13<sup>th</sup> September 2022

**Re.: CIE – Dart West+Railway Order – Plot DW.025.P61(A) – Joan Reynolds,  
Edel Reynolds, Madeline Reynolds and Francis Anthony Reynolds**

Proposed Ongar to Barnhill
 Distributor Road to be
 constructed by others

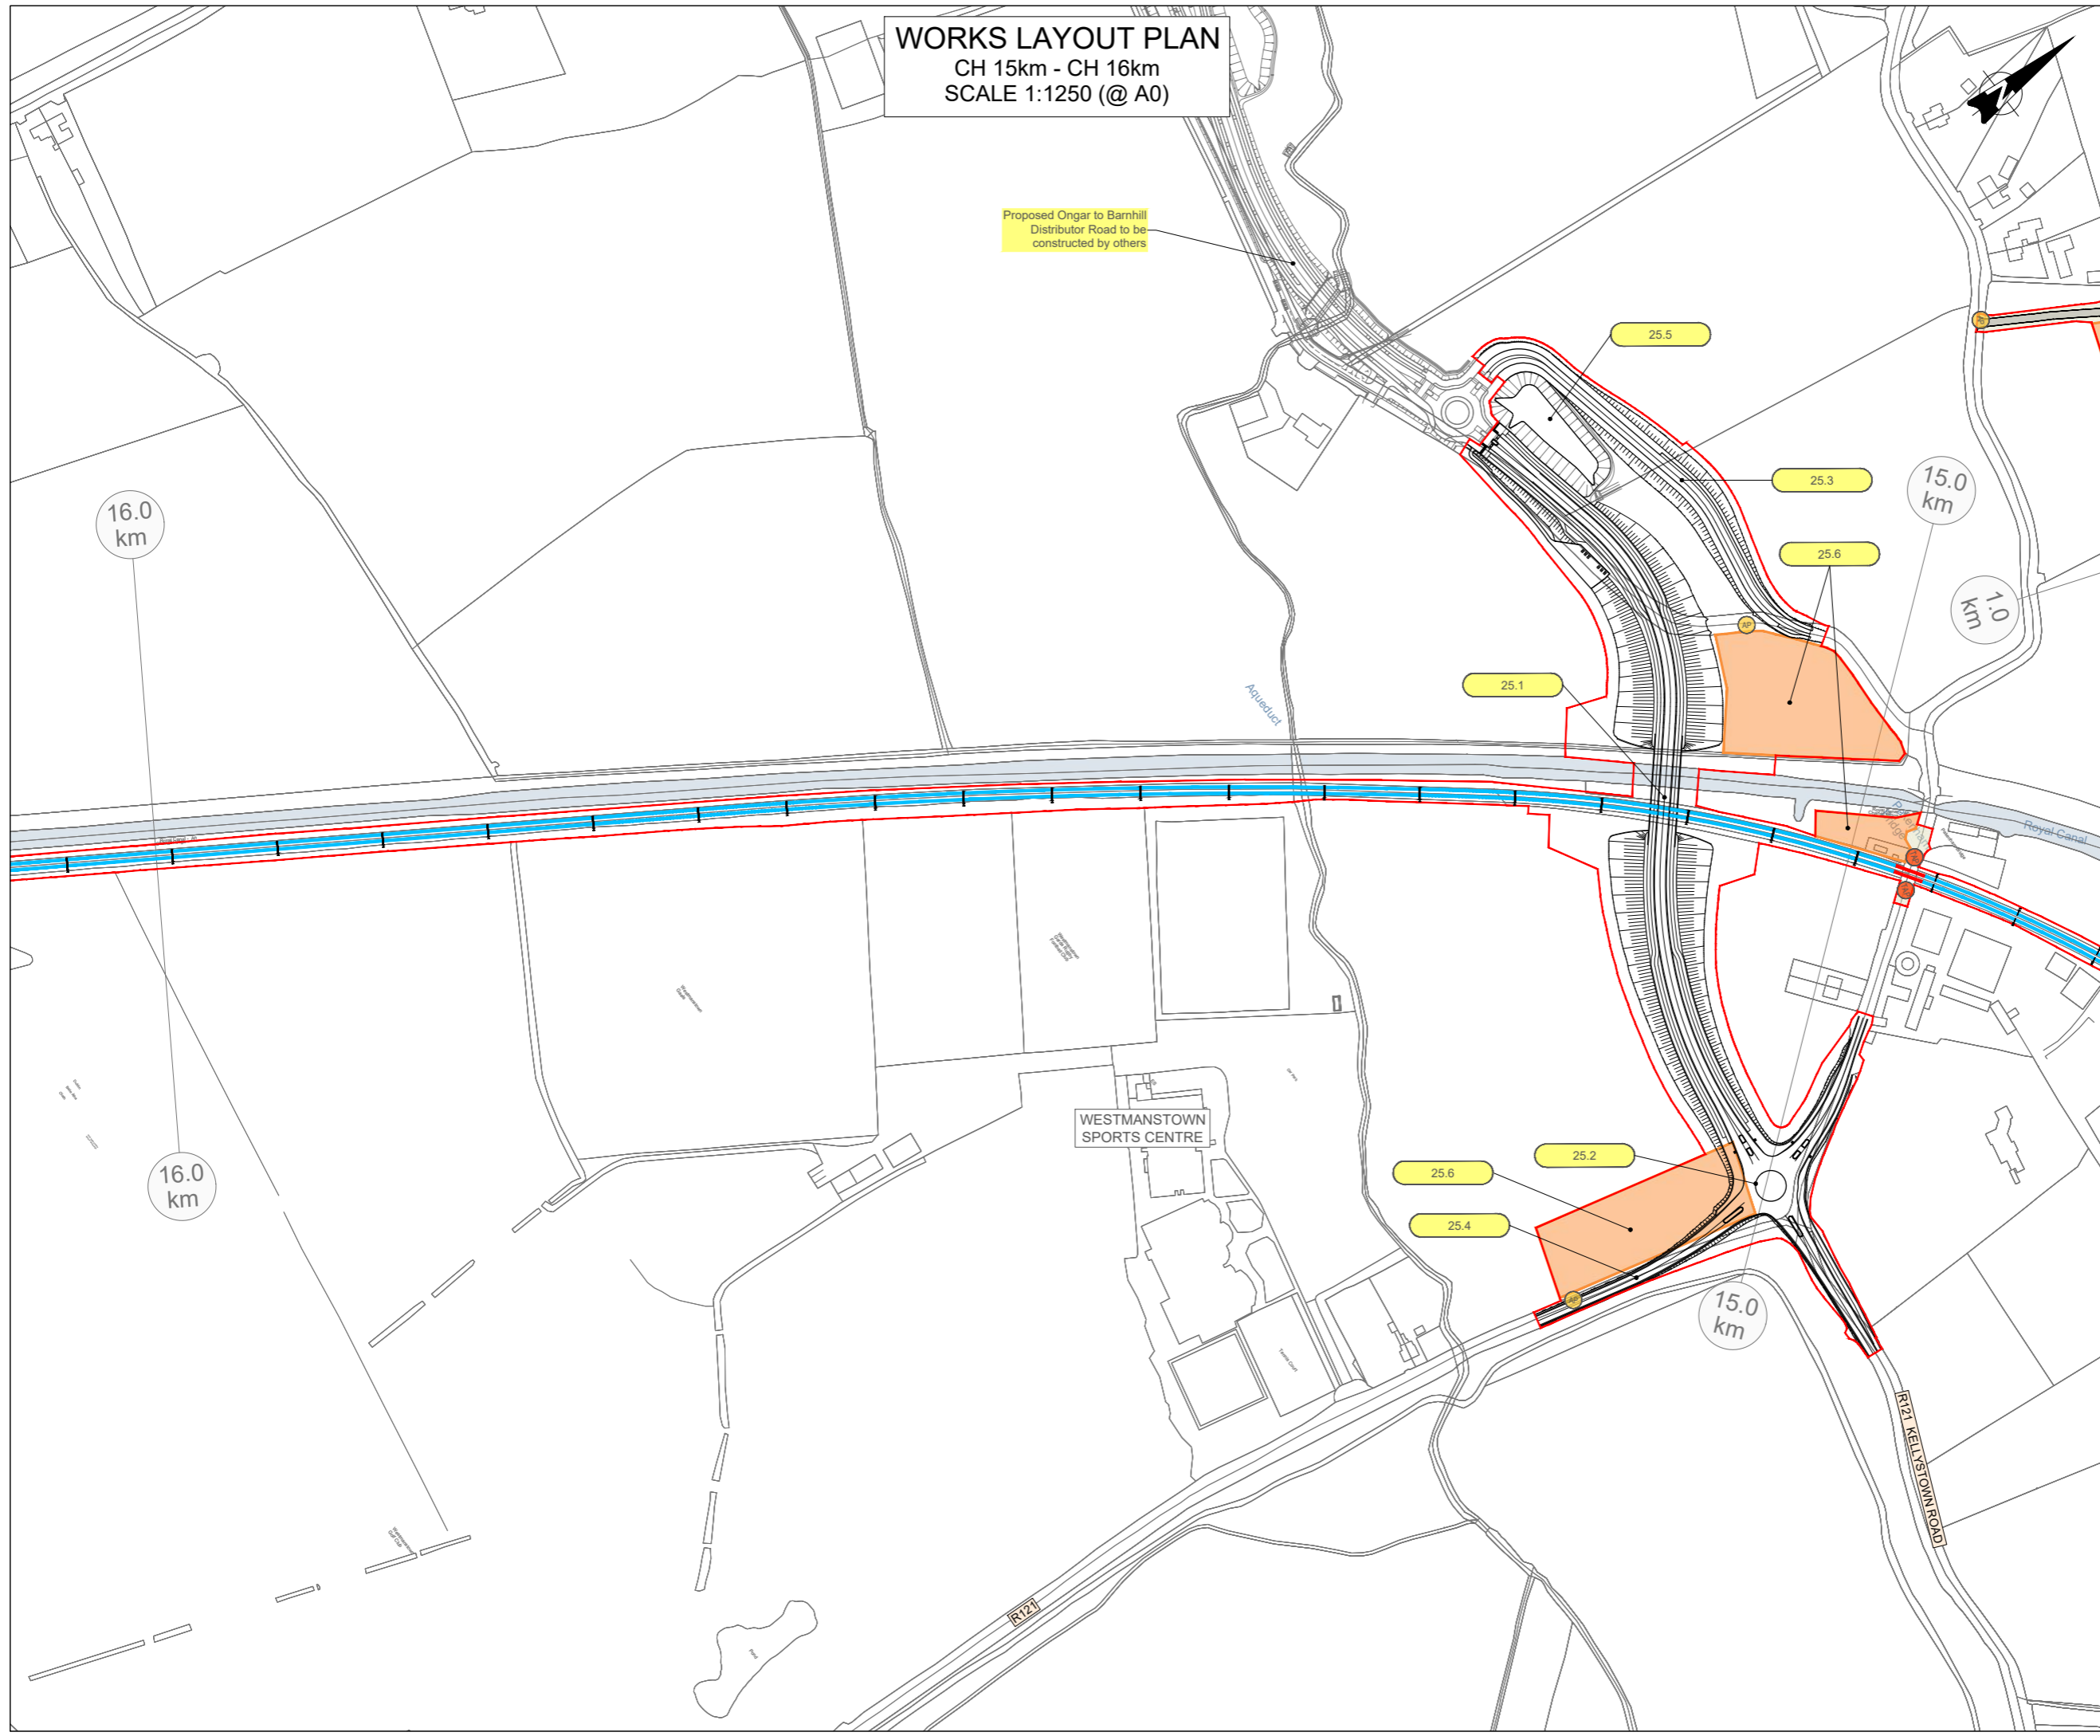
3. The Bord will note that the Works Layout Plan No. WP025 shows the proposed CIE Scheme connecting into "the proposed Ongar to Barnhill Distributor Road to be constructed by others". This is a cause of grave concern. The Bord will recall that Fingal made an application for a CPO – (Ongar to Barnhill Distributor Road) Order 2008, Reference No. 06F.CH3079, on the 3<sup>rd</sup> July 2008. Following intense consultation with Fingal and their Engineers agreement was reached between the Parties that a suite of work would be included in the proposed scheme, providing services to the retained Reynolds lands which are zoned for residential development. On foot of this agreement, the claimants withdrew their objection and the CPO was subsequently confirmed and a Notice to Treat was served on the 20<sup>th</sup> May 2010. Since 2010, I have been unable to submit a claim for compensation as Fingal have not been in a position to provide any final, or any drawings for the scheme reflecting the works that were agreed between the Parties. For the past number of years, Fingal have been "reviewing" whether or not they intend to proceed with the CPO or whether to accept that they have in fact abandoned it. As at the date hereof, Fingal have not made any decision in this regard. In relation to the drawing mentioned above for the currently proposed scheme, it is not clear whether the Ongar Scheme referred to on CIE's drawing is the same as the Scheme for which a Notice to Treat was served in 2010 or whether it is a different Scheme and for which no CPO exists. I would argue that even if it is the former, then it appears that that CPO has been abandoned in any event. There is therefore no certainty that CIE can build or

complete the current scheme as shown on the drawings presented to the Bord.
